# 2 Chester Square, London SW1

Non-material Amendment

Application References 20/02304/FULL

Document Control	
Document Title	1901(RP)004
Contributions	Megan Ebanks
Company	MEA Studio Ltd
Location	London
Revision	\
Date	16 <sup>th</sup> March 2021
Details	Non-material Amendment
Name	Megan Ebanks
Title	Director
Address	MEA Studio Ltd 10 Arbutnot Road London SE14 5NP

Drawing Number  
1901-P12-089

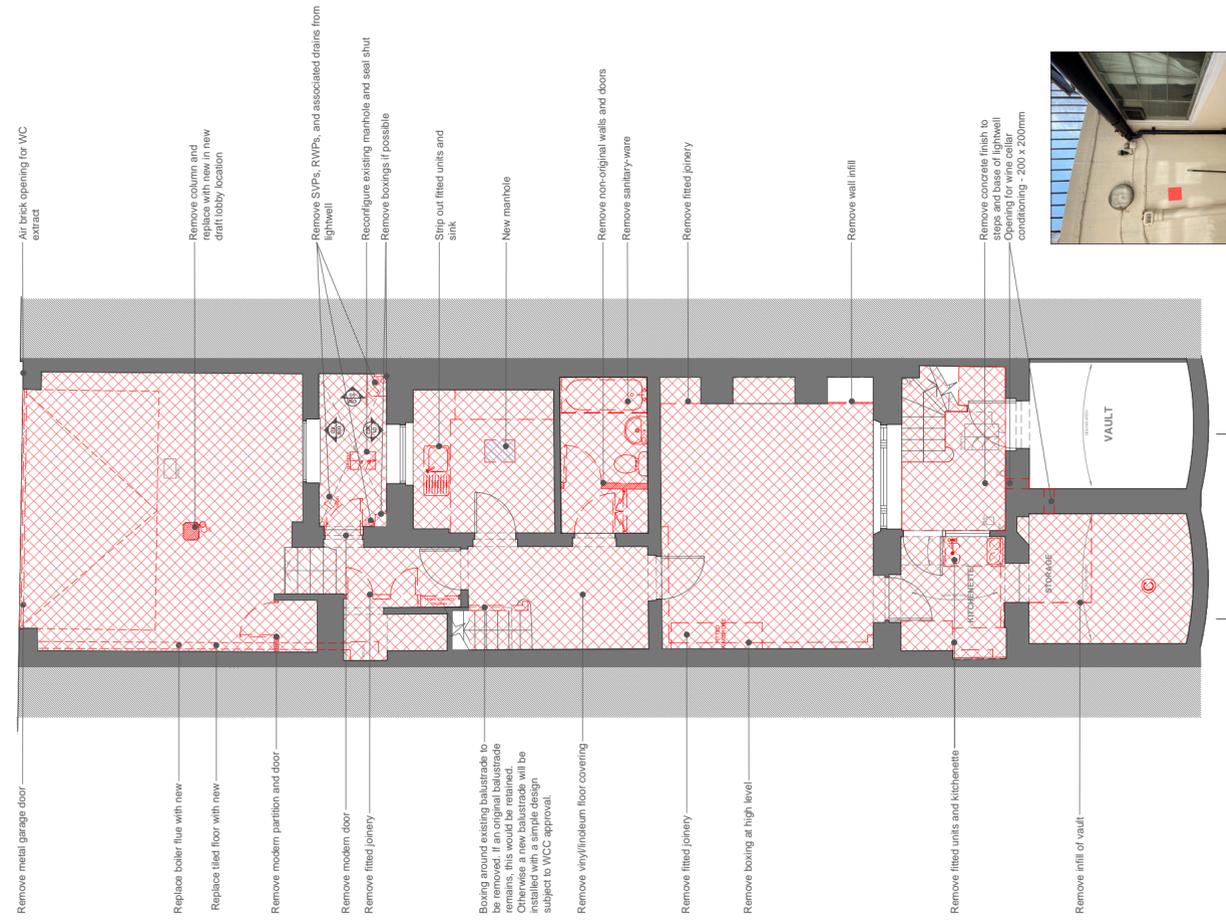
This report is a summary of the minor amendments that has altered the original proposed design in one internal area. The amendment is the profile of the new slab to the opened up under pavement vault at lower ground floor. Instead of a flat slab, we would like to recess the central portion to increase the headroom for ease of access.

Drawing Number  
1901-P12-201

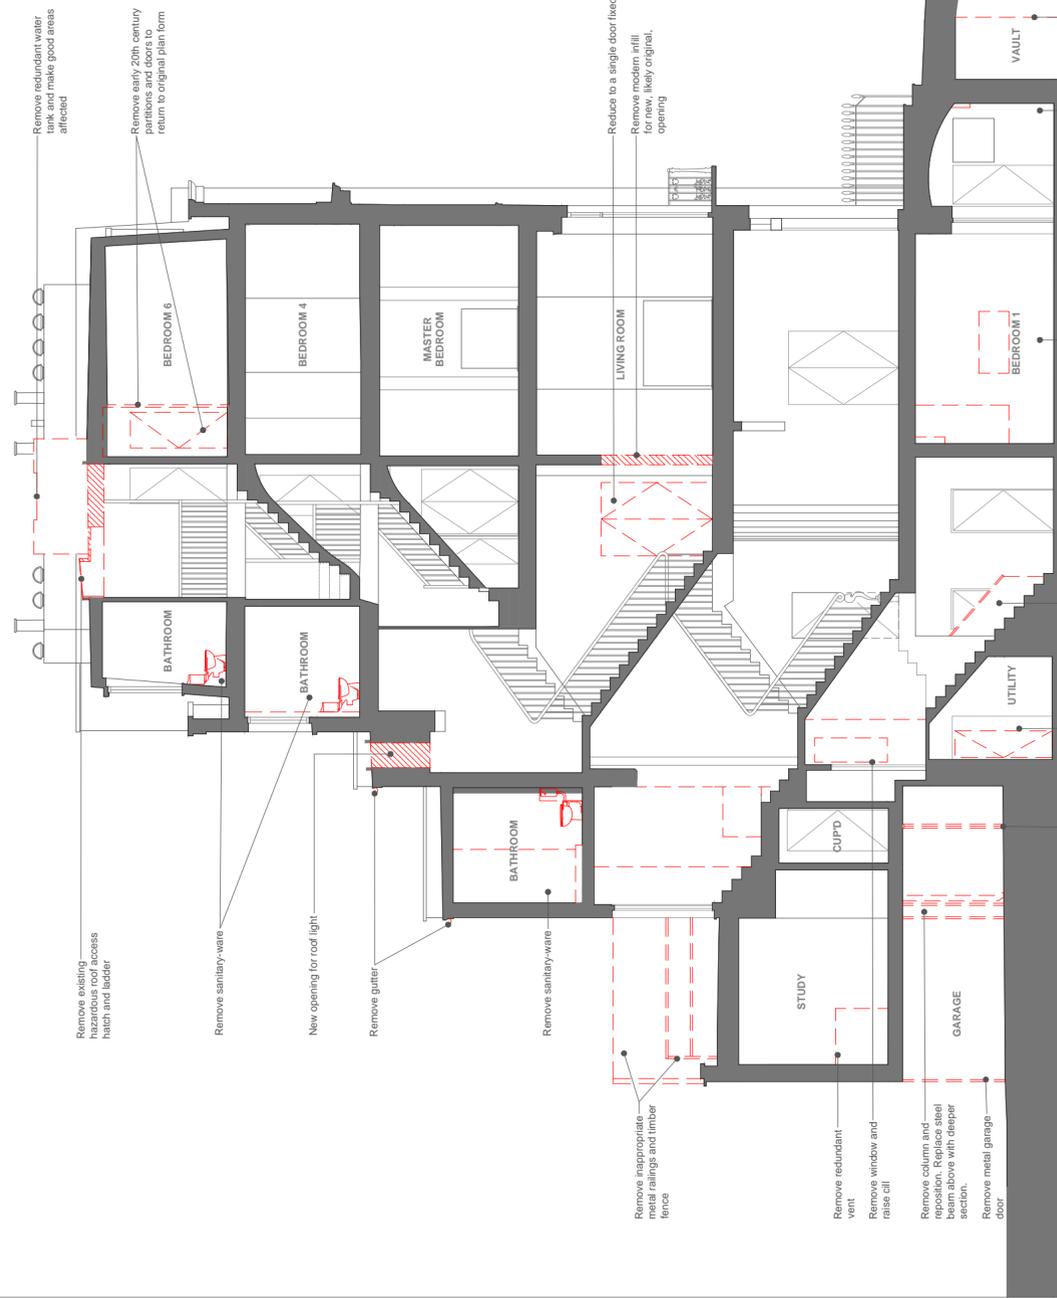
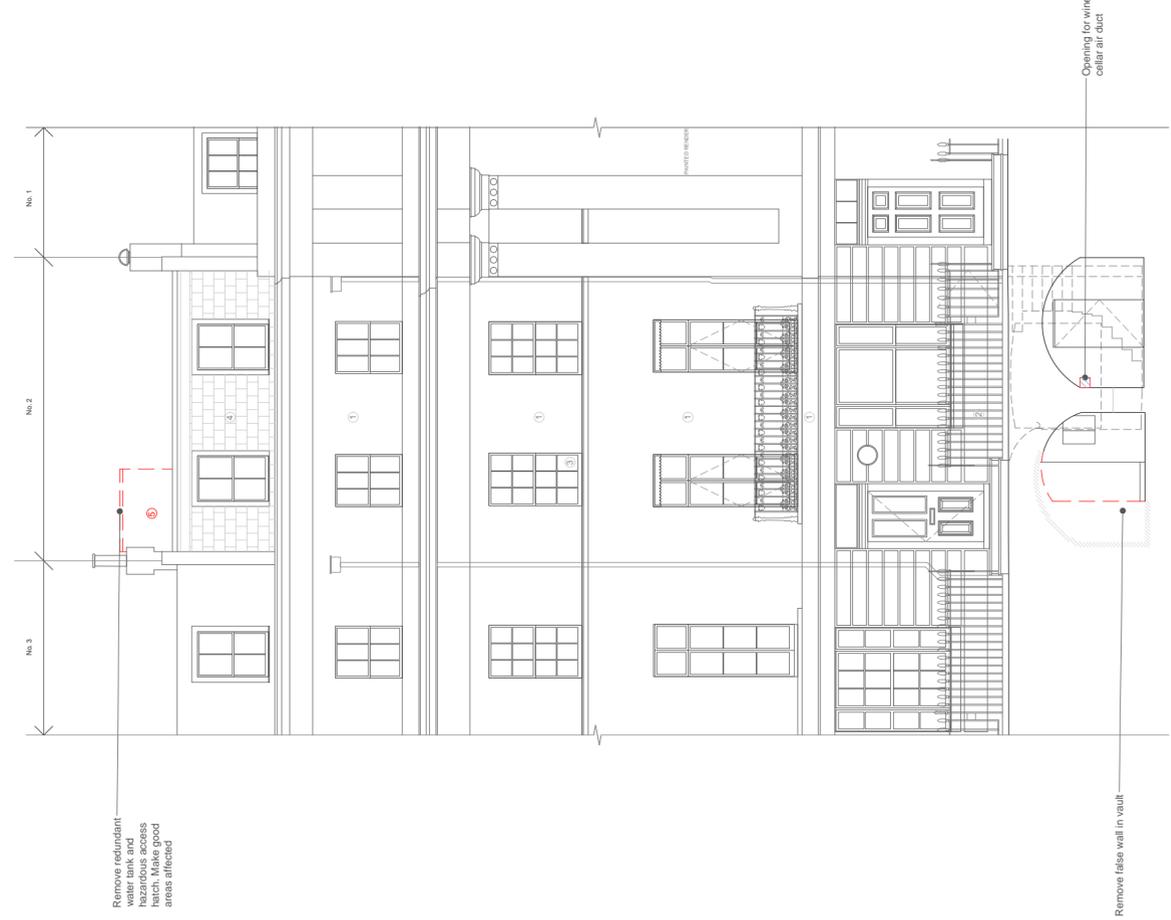
As originally proposed and approved, the modern infill wall to the under pavement vault has been removed. We discovered a very damp vault beyond but the walls and ceiling are structurally sound. The floor however is a mix of dirt, a portion of concrete slab and some rubble. We would like to propose that the new slab to go in would have a recess in the centre to be able to stand up. We propose a recess in the centre so we do not disturb the existing foundations of the vault. We would also cast 3 steps to go down into the recessed part.
